CIVIL ENGINEERING INFRASTRUCTURE REPORT

**STRATEGIC HOUSING DEVELOPMENT AT
ST. JOSEPH'S HOUSE AND ADJOINING PROPERTIES,
LEOPARDSTOWN**

CIVIL ENGINEERING INFRASTRUCTURE
REPORT FOR PLANNING

19.236-IR-01

SCALE @ A1: 1:100
SCALE @ A3: 1:200

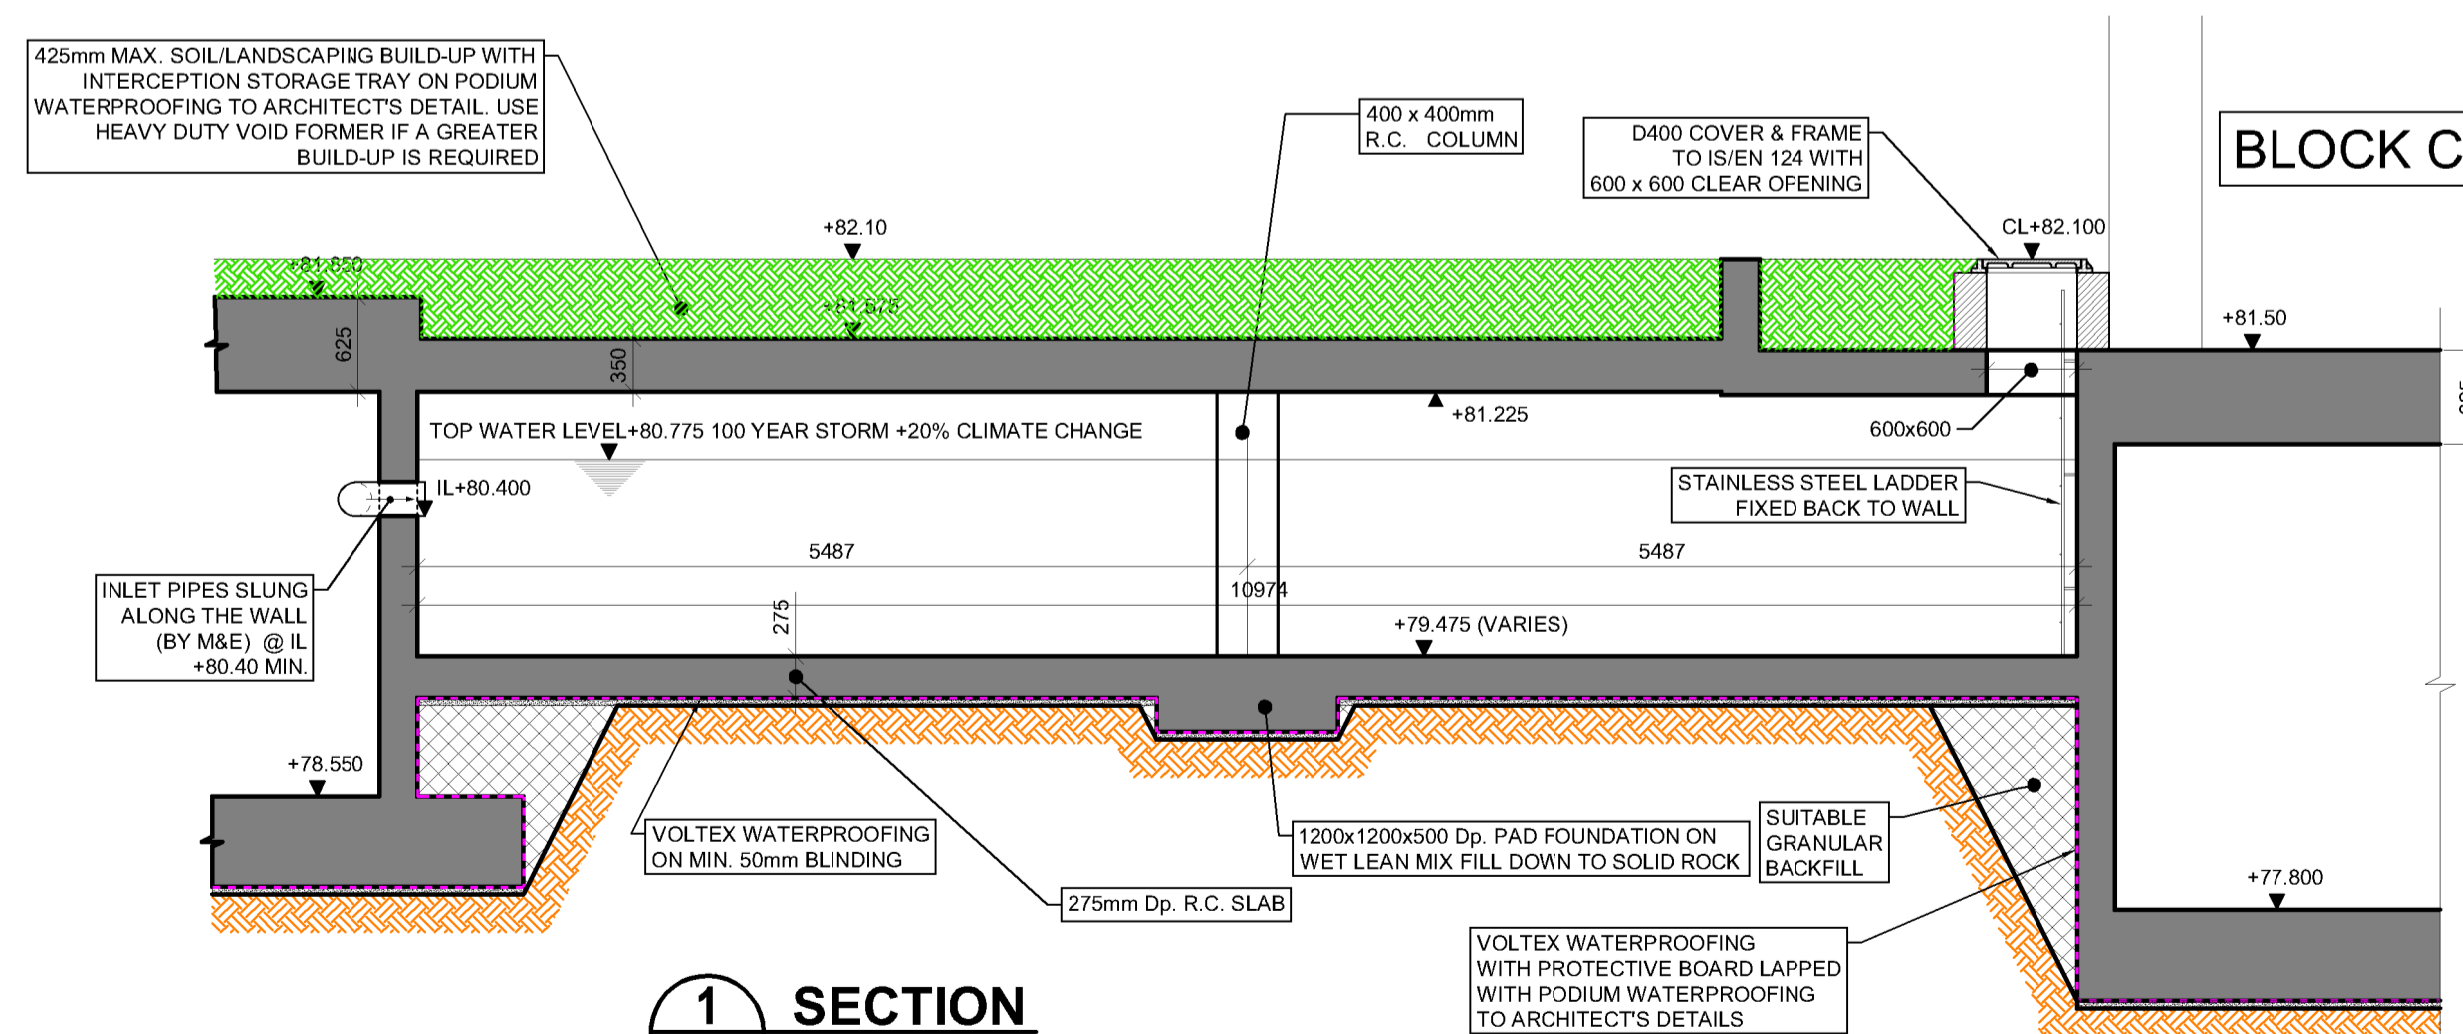
8. *As standard, the applicant is required to demonstrate by calculation in the report and by representation on a drawing that the proposed green roof extents are in accordance with the Council's Green Roof Policy such that the minimum coverage requirement of 60% is achieved. The applicant shall also provide details of maintenance access to the green roofs and should note that, in the absence of a stairwell type access to the roof, provision should be made for alternative maintenance and access arrangements such as external mobile access that will be centrally managed. The applicant should comment on the compatibility of the green roof with PV panels if they are to be incorporated into the design.*

BMCE: See Section 2.3.11 which outlines full roof availability and estimated coverage well in excess of 60% green roof proposed on new buildings. Also refer to C1005 for the proposed green roof locations. Please see the architectural drawings for access details to the roof areas. All

maintenance access to green roofs will be accessed from AOVs within top storey stair core, with the exception of the roof of the 4 storey element of Block B, can be accessed by a hatch in the corridor. PV panels are not proposed on this project.

DRAWING No. **BPR-BMD-00-ZZ-DR-C-1207** ISSUE **PL3**

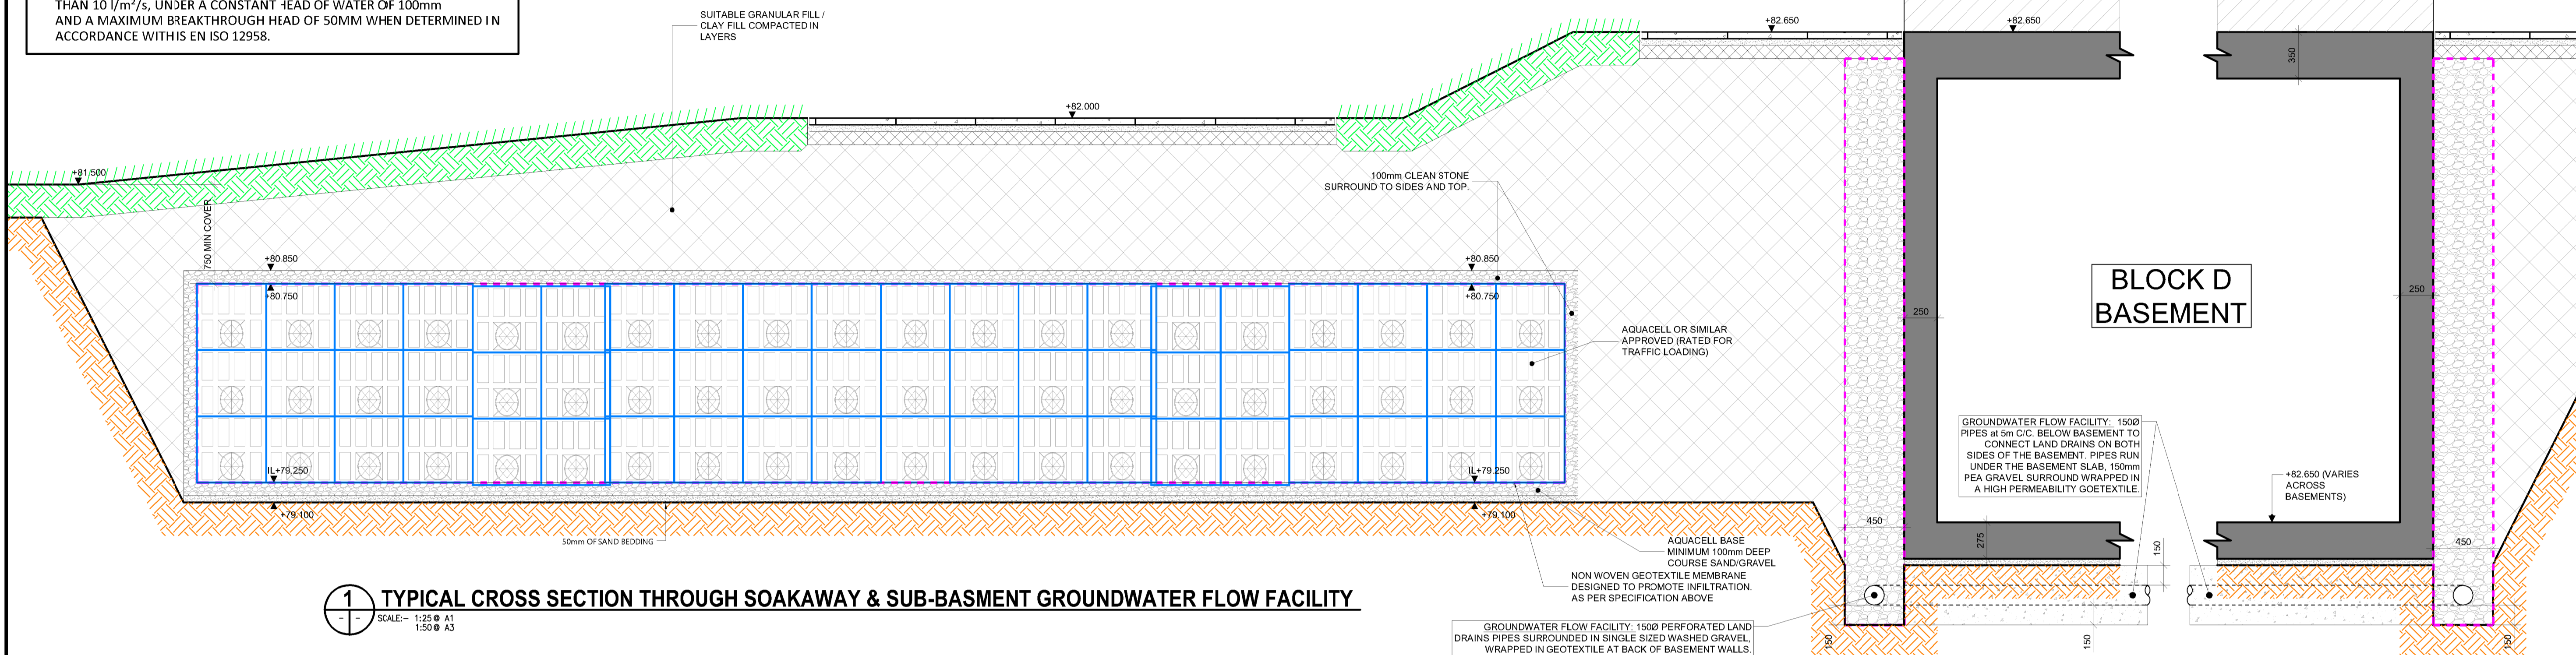
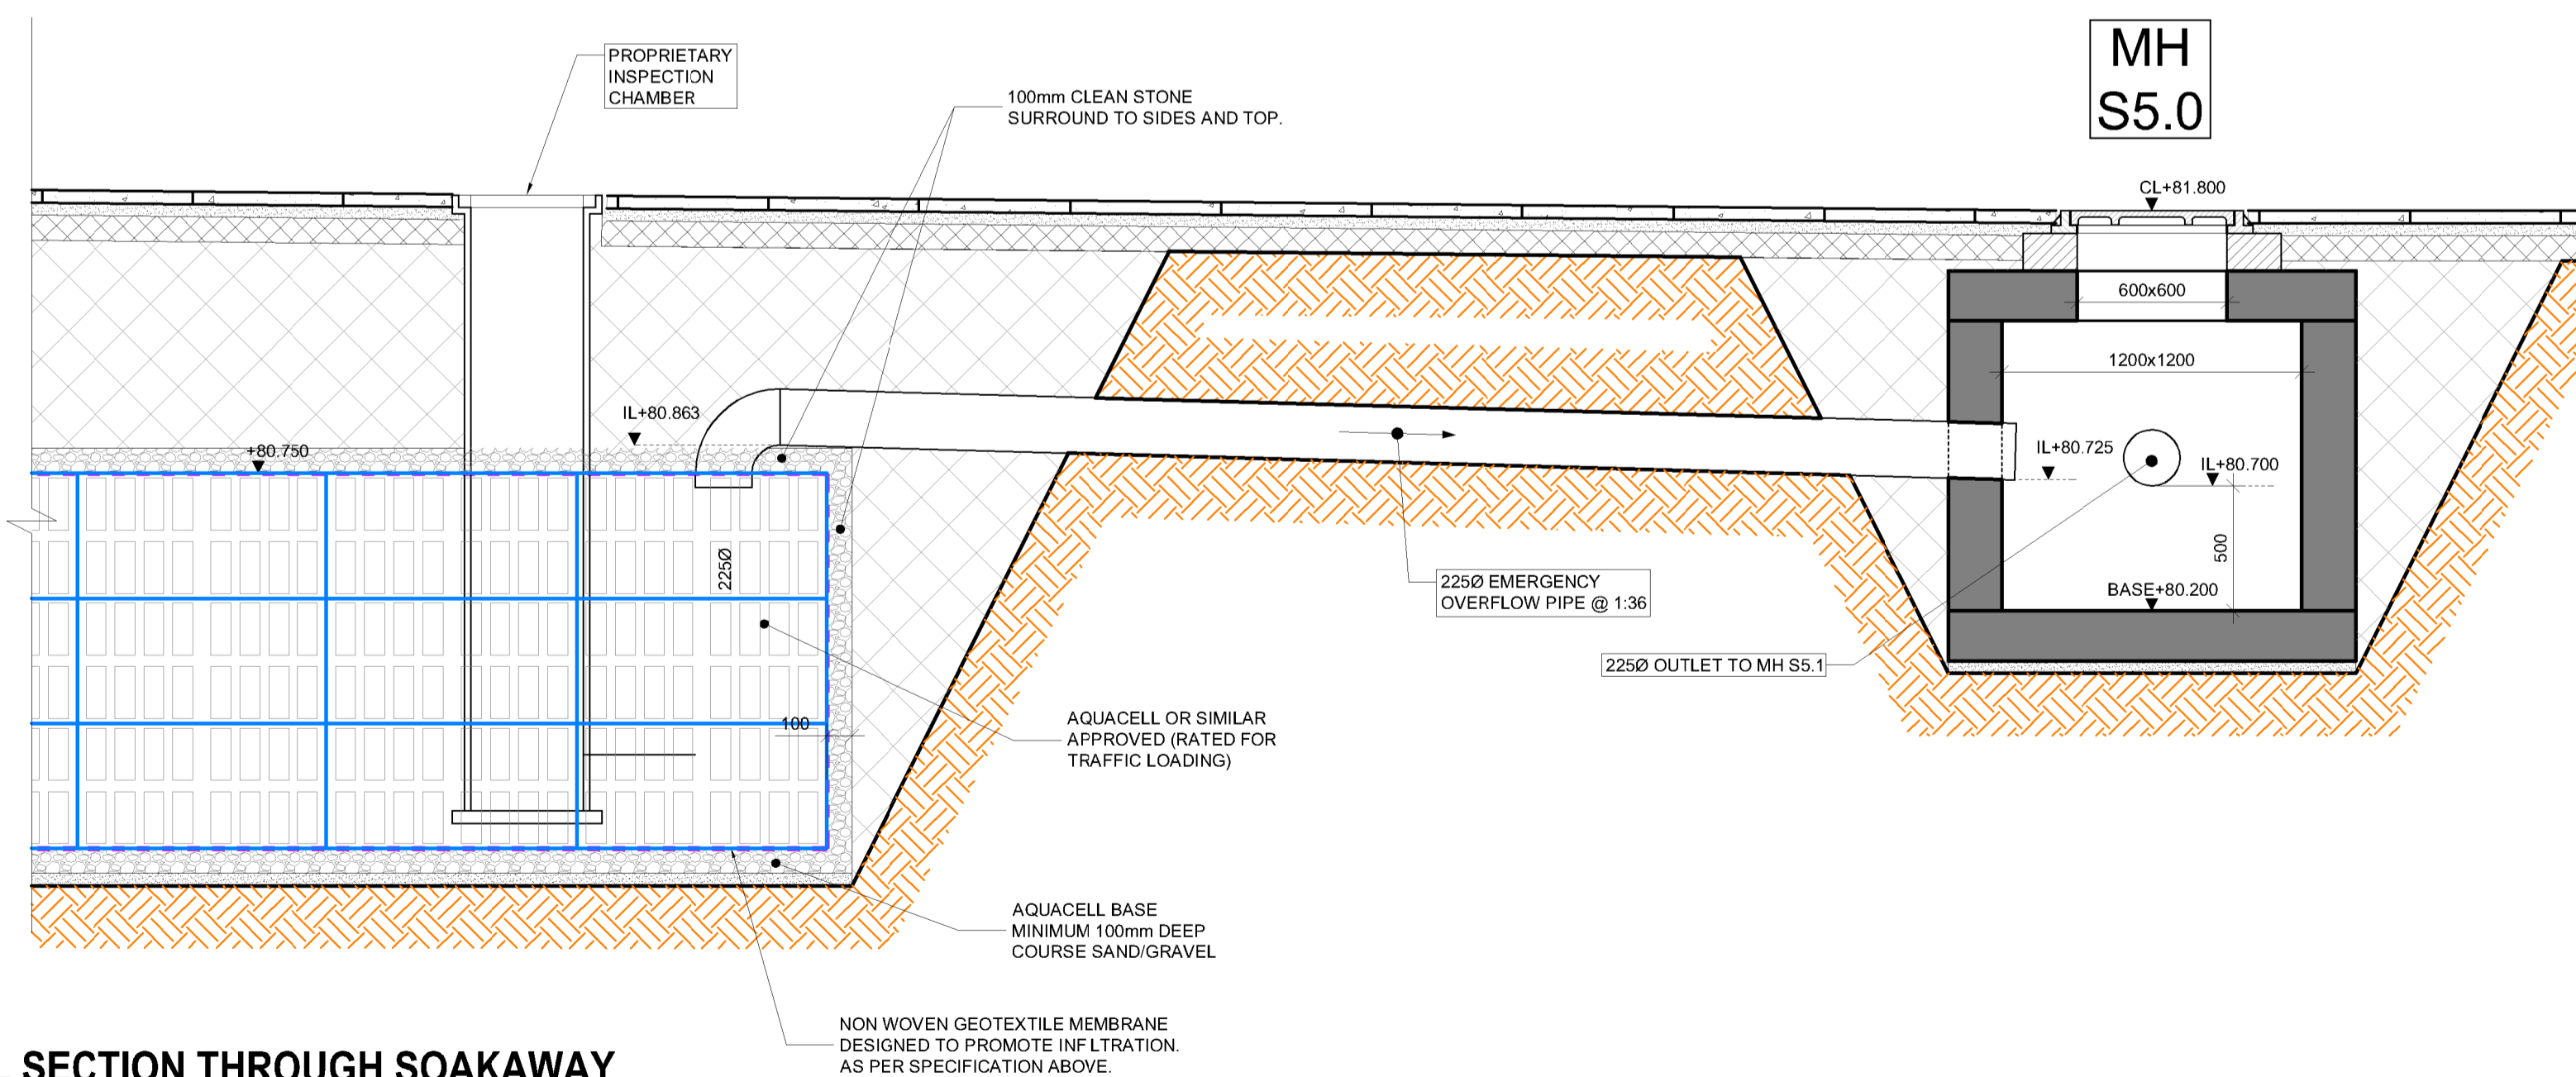
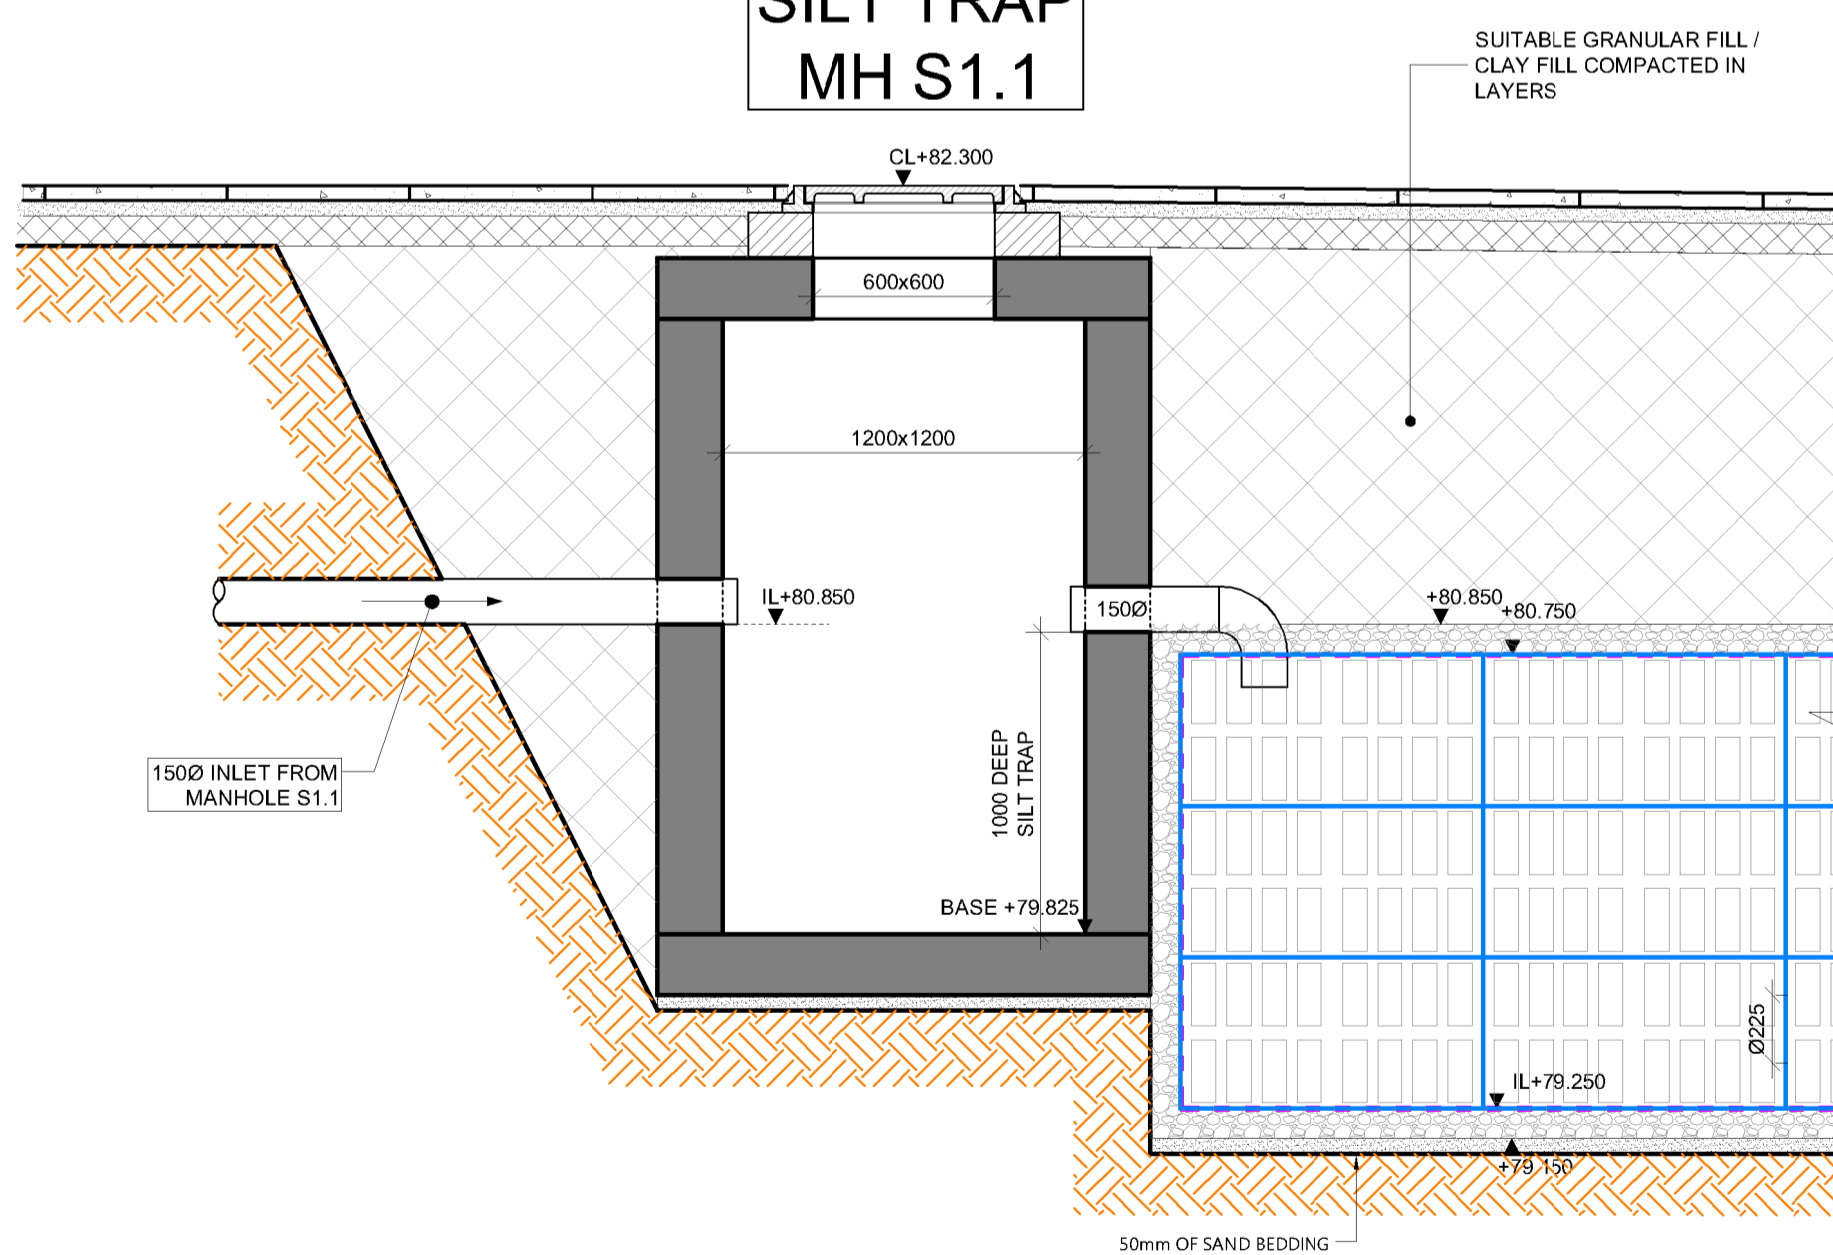
5. *An overflow has been proposed from the soakpit to the attenuation tank in sub catchment 1. The applicant is requested to comment on the provision of additional capacity in the storage tank to accommodate any such overflow or the impact on a surcharged soakpit on sub catchment 1.*

BMCE: The overflow should not have been flowing into the attenuation tank. It has now been piped separately directly to the outfall manhole to Silverpines. It is noted that this is an emergency overflow only and that the soakaway has been conservatively designed in accordance with local site investigations and industry standard guidance Ciria SuDS Manual C753. See drawing C1000.
